From: Amanda Scholes on behalf of Planning.Responses
Sent: 23 February 2021 08:33
To: Planning Scanning
Subject: FW: Flamsteed - BN/2/21/DOC

From: Finlay Gardner <Finlay.Gardner@arun.gov.uk>
Sent: 22 February 2021 15:37
To: Planning.Responses <Planning.Responses@arun.gov.uk>
Subject: FW: Flamsteed - BN/2/21/DOC

They also included that 'The applicant needs to address the comments in the enclosed email dated 22ndDec 2020. The attached drawing 'Installation Arrangement Side Elevation' should also be included as part of the submission.

| Project number | FLA-19            | D102          |

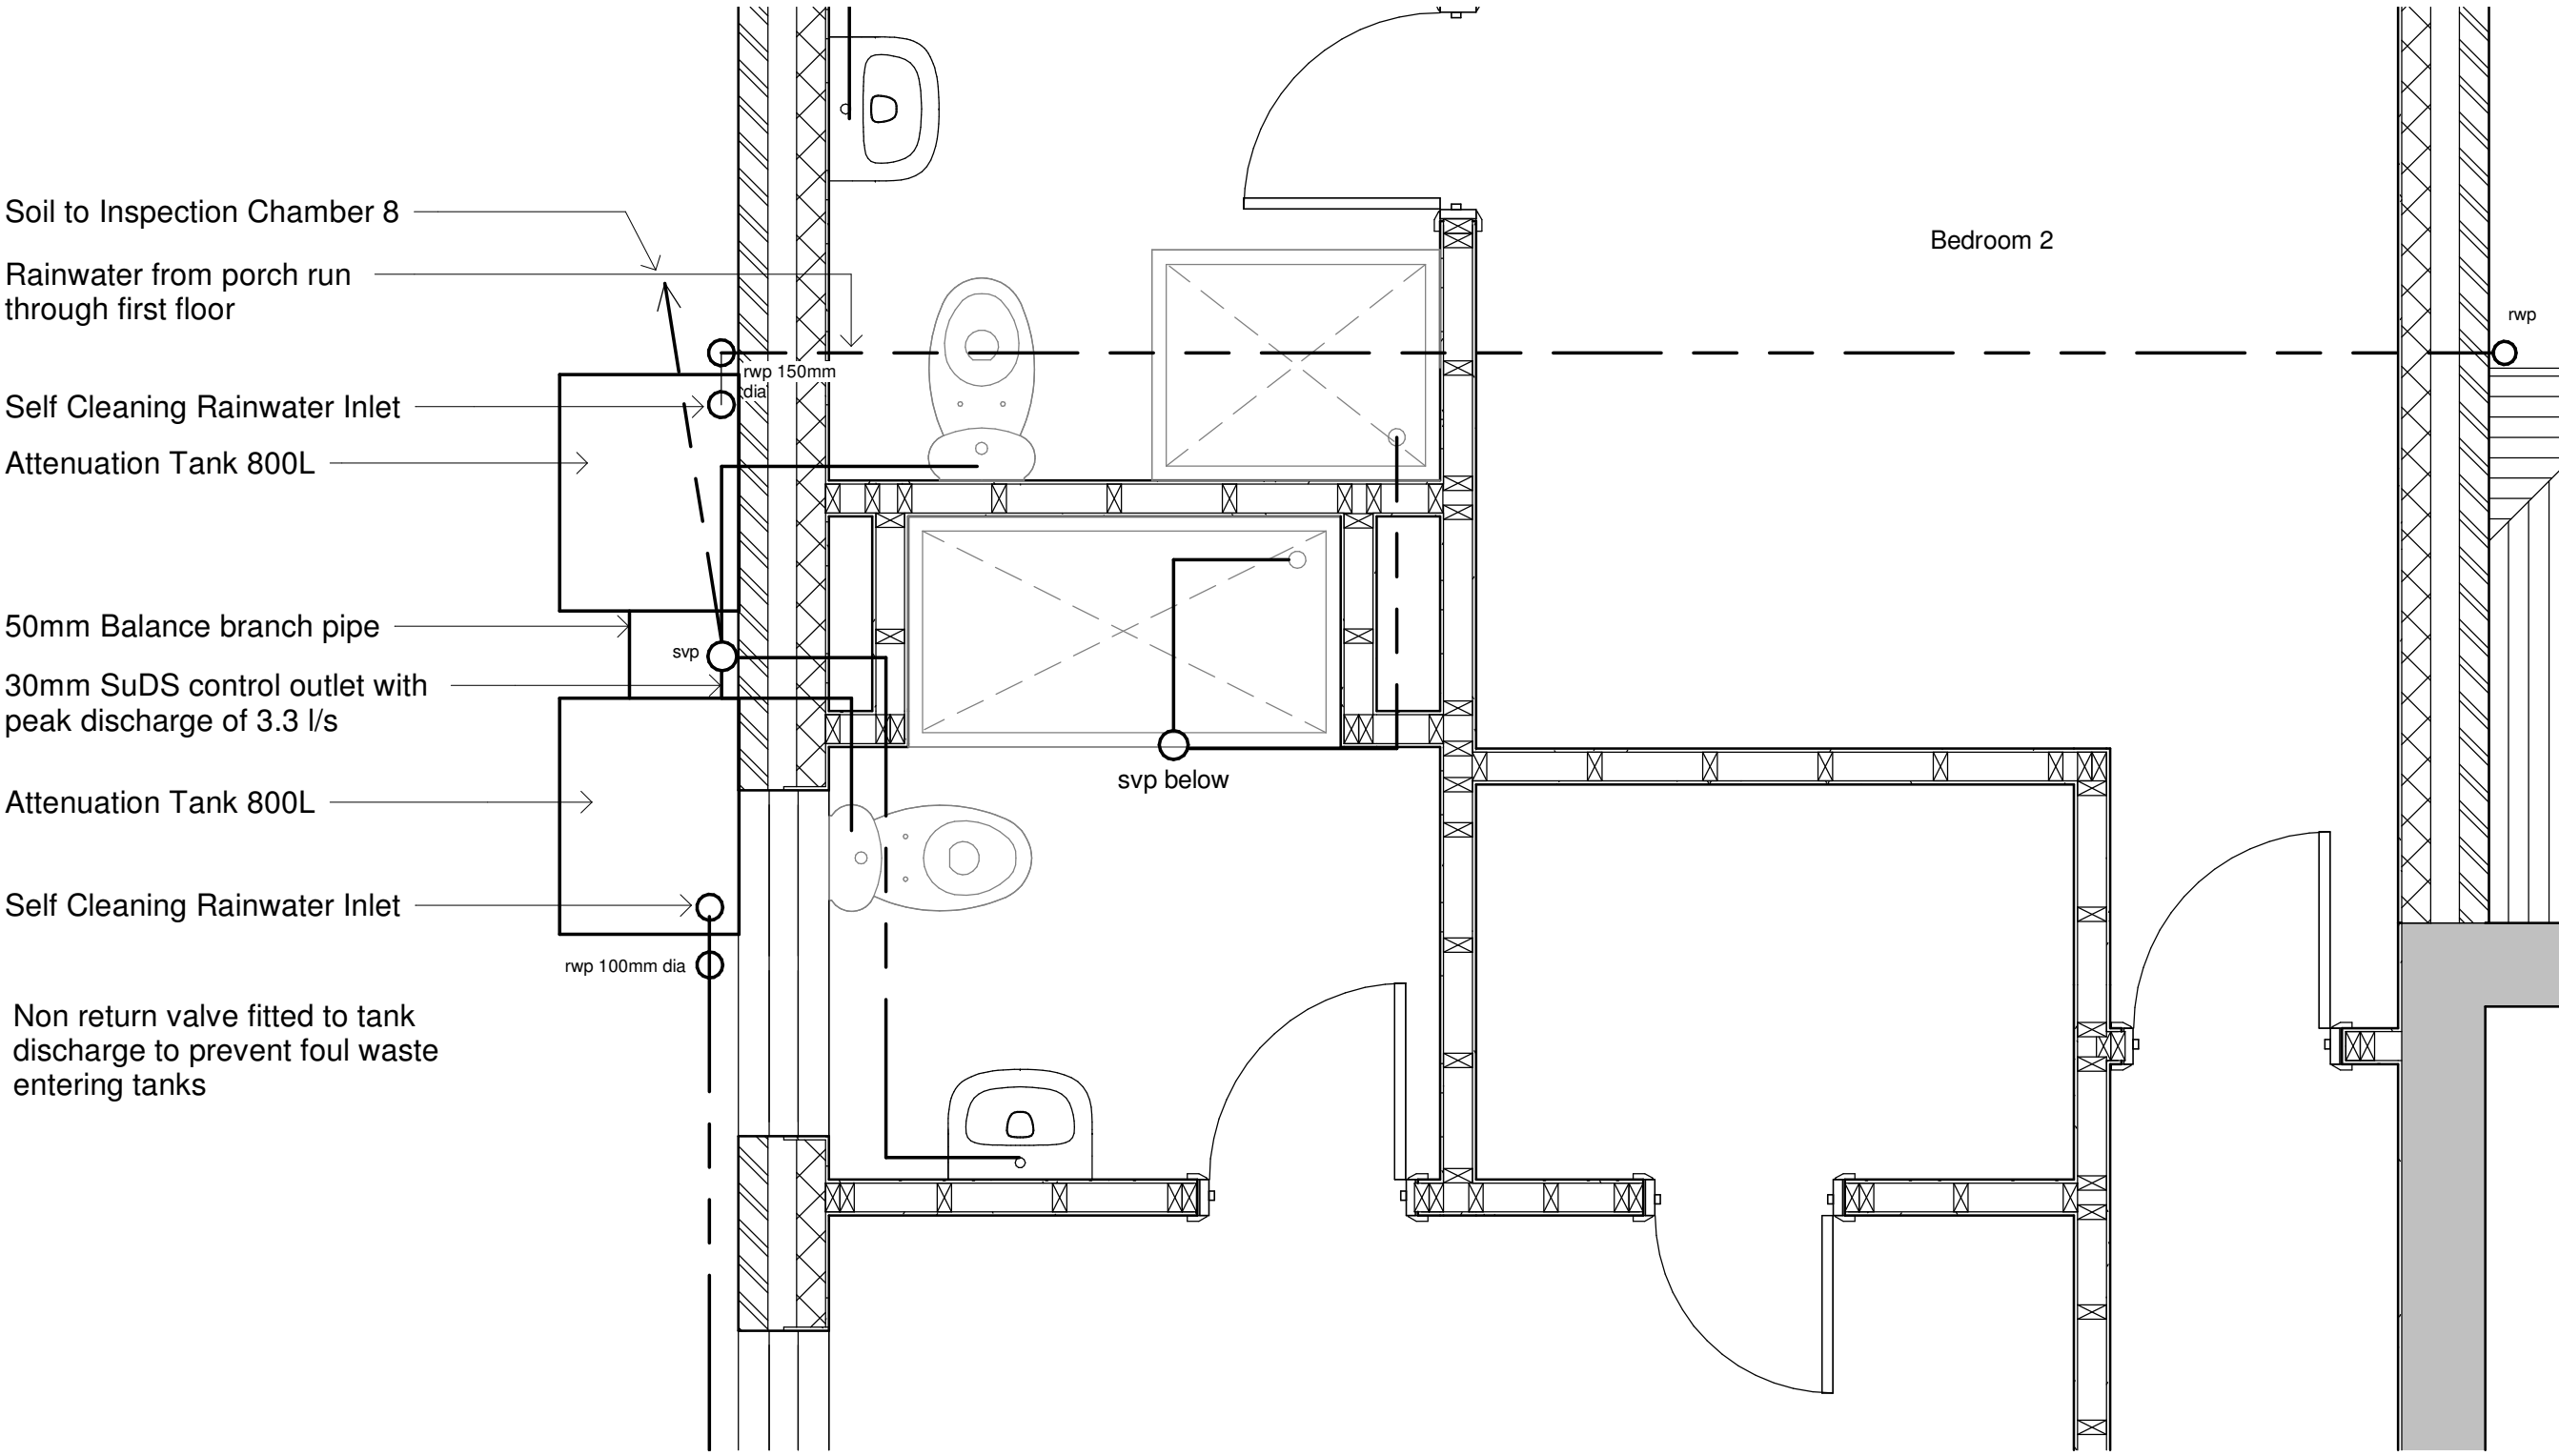
2. Please confirm that there are only two rainwater pipes on the property post development. I know they are shown on the elevations but also need to be included on drg. D102.

4. The notes on drg. D102 reference the use of soakaways – note needs to be removed.
5. Add pipe gradients to drg. D102 for the combined pipework ie. for each length. Manhole cover levels for the combined system should also be provided (with the invert levels relative to these).

2. The two rainwater pipes were required on drawing D102. These are on D102, wrong drawing sent. See comment 4 below.

4. The notes on Drg D102 references the use of soakaways and should be removed. You are correct, I sent the wrong drawing back, please find attached the updated Drawings D102

5. All levels and falls are on D102, they were on the version you had previously.
